To: An Coimisiún Pleanála

25/11/2025

Re: ABP-322154-25 (2560003) - Briskalagh Ltd.

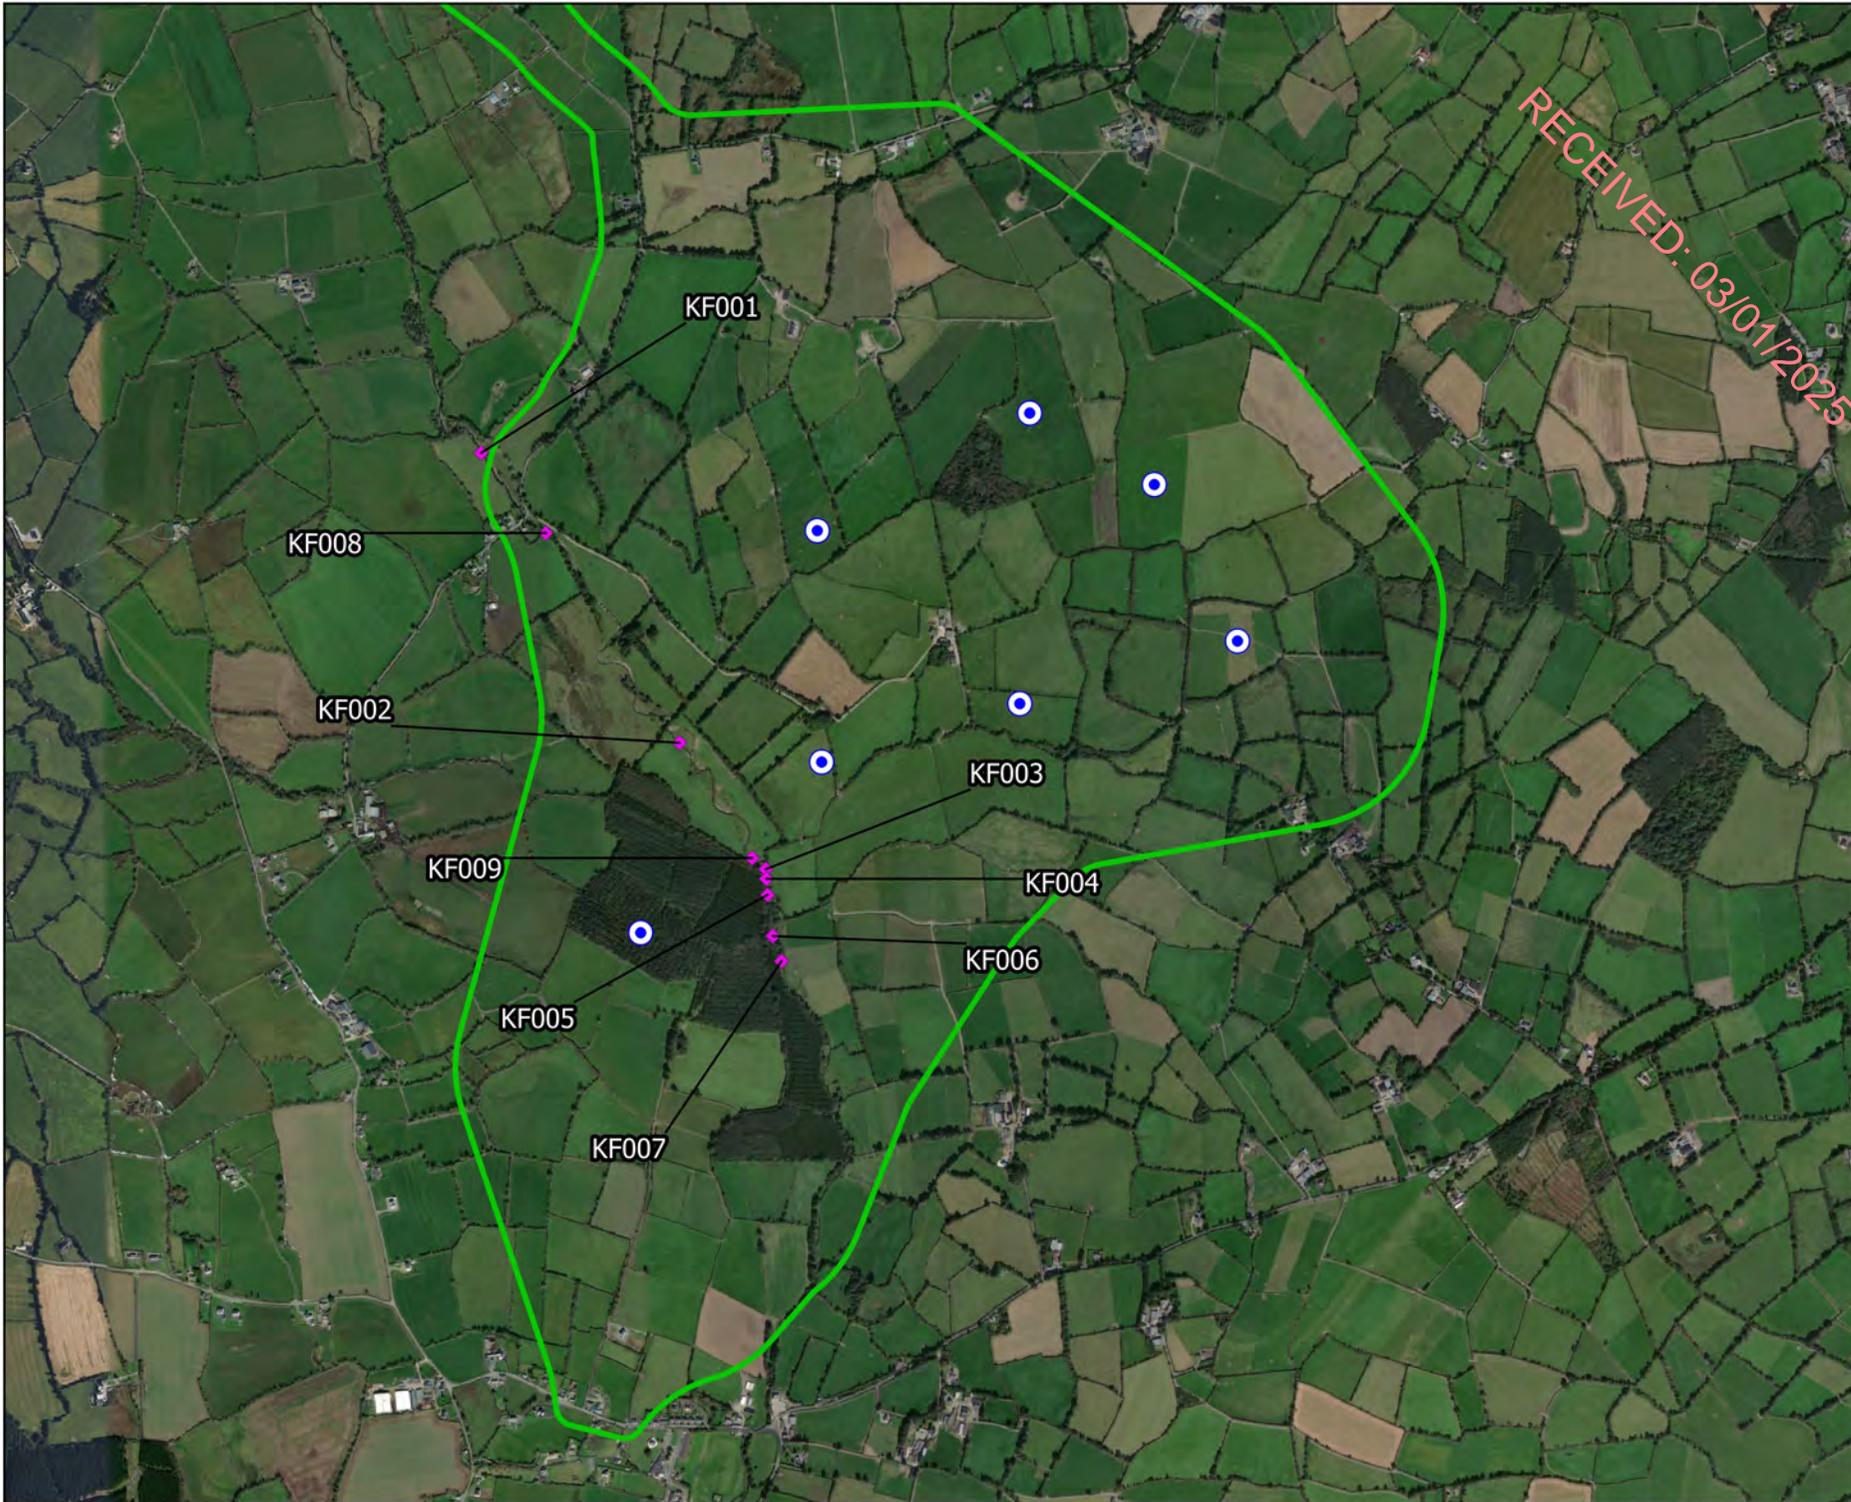
3. For item 3 the Commission needs to satisfy itself that the proposed development will not impact on the Kingfisher which is the designated species for the SPA. This includes not only any mitigation proposed but that the survey work is sufficient and robust for its purpose.
